**Subject:** RE: 2023/90076 - Units A & B, Leeds Road Retail Park - CPO response

Noting the CPO response and taking each point in turn:

drawing title
Proposed Elevations

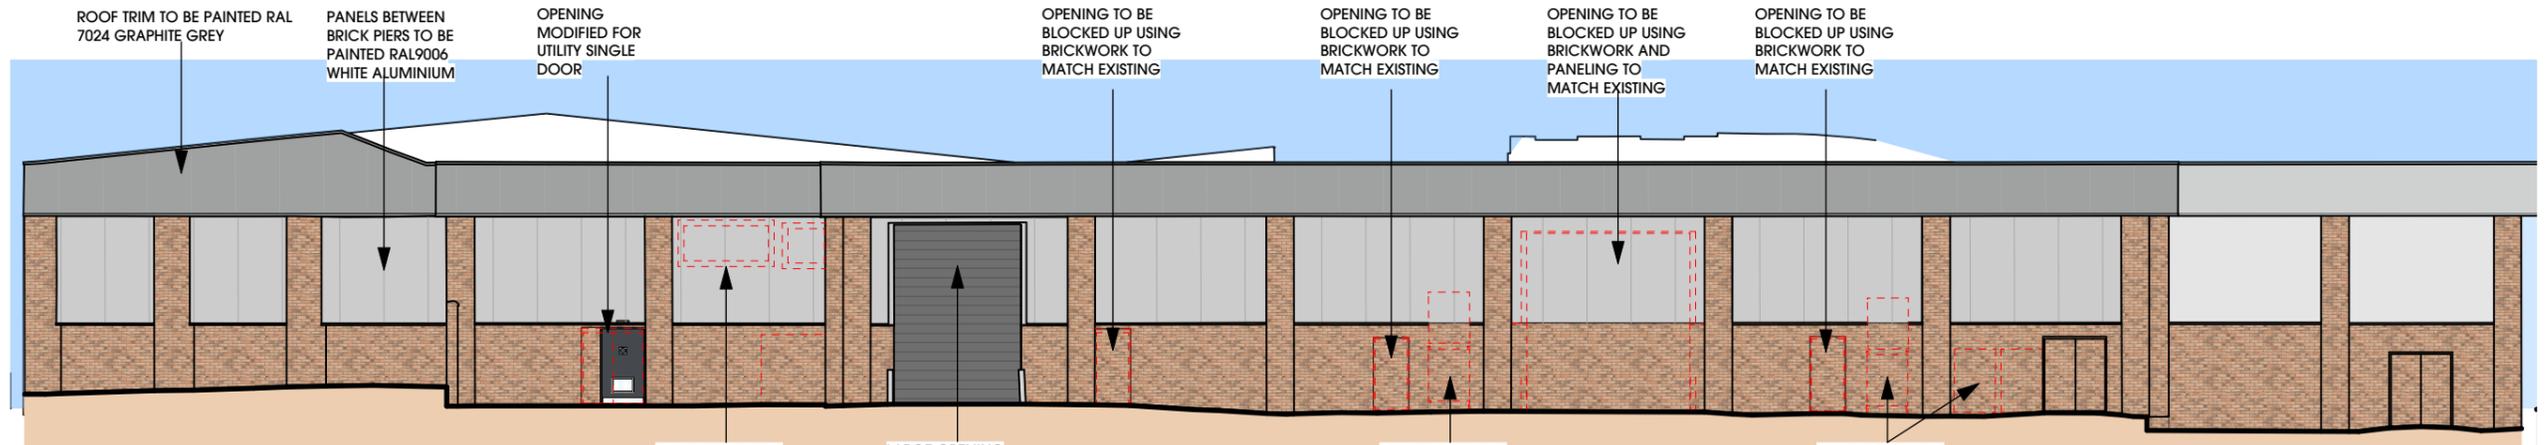
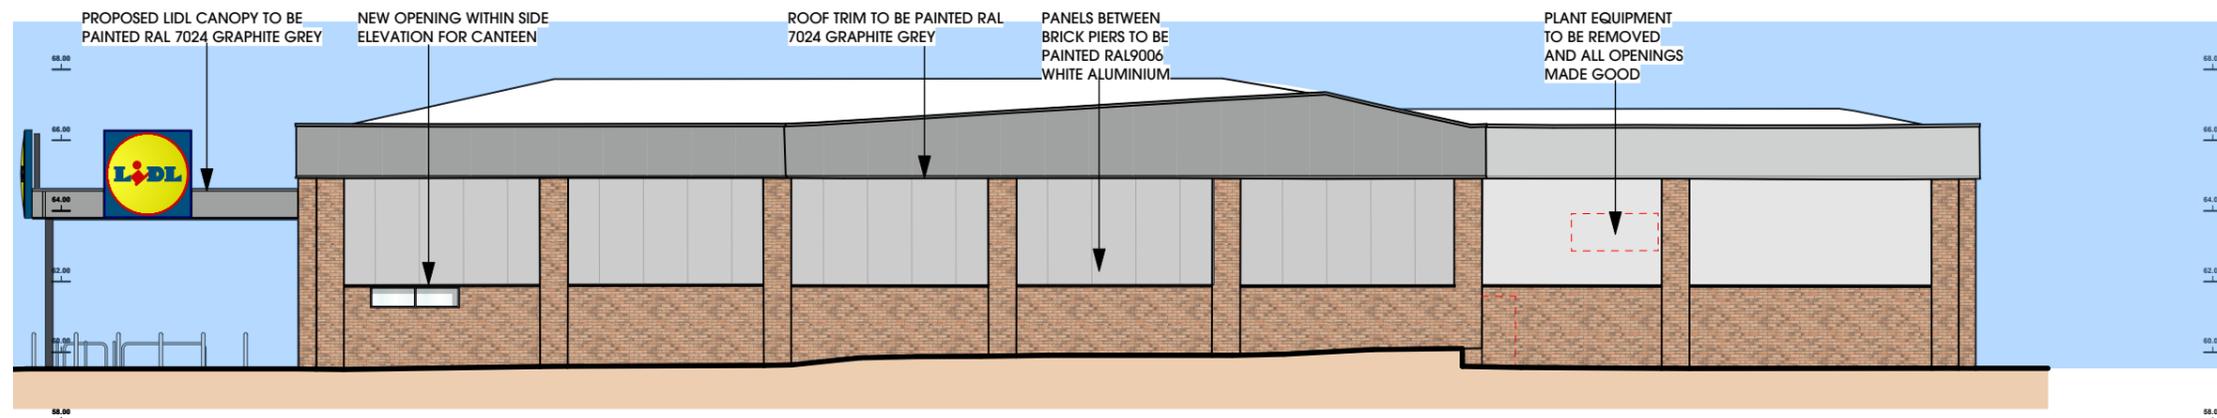
3. Canteen window – the window is in the optimum location for the internal configuration of the canteen and is needed to provide some natural light. Locating the window on the front elevation would look clunky and out of context with the remainder of the elevation. We do not propose an amendment on this point.

drawing title
Proposed Site Plan

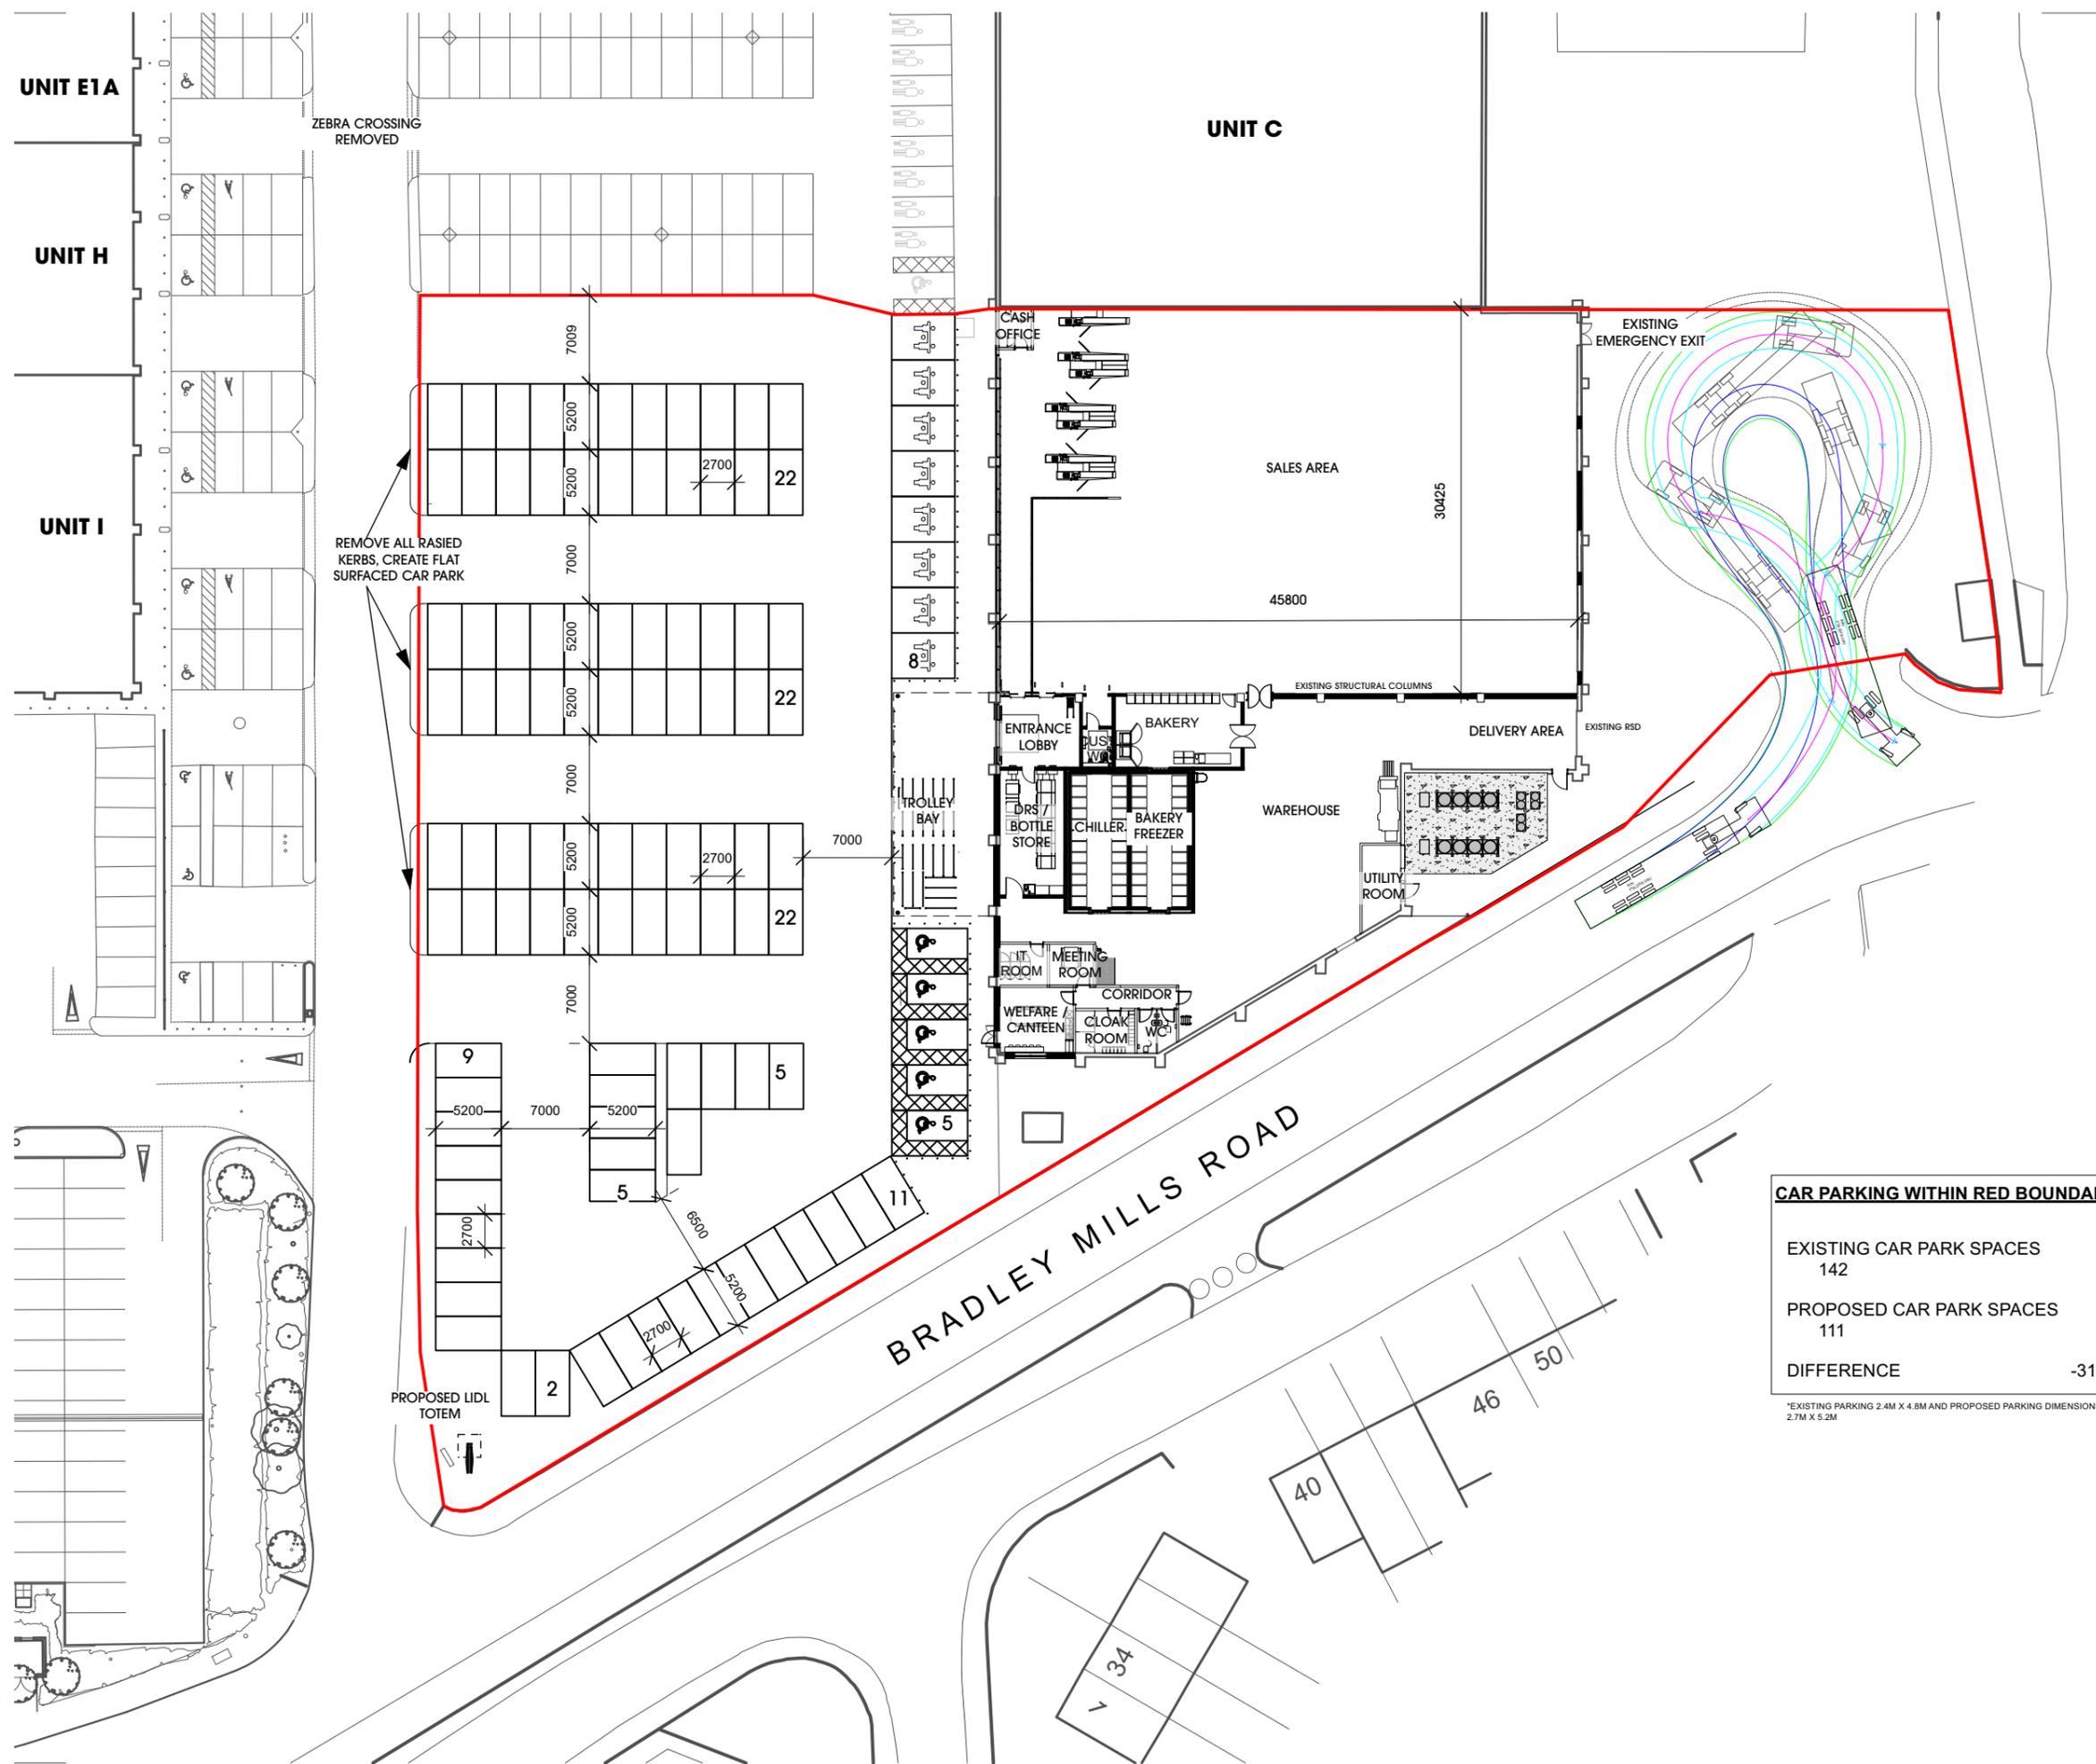
4. Cycle / motorcycle security – the external layout is being continually refined and exact details are not fixed at this stage. However, we would be willing to consider a condition for providing details pre-opening.

5. Boundary treatments – almost all existing landscaping will be retained, apart from a small area of planting removed to improve pedestrian and cycle access from Bradley Mills Road.
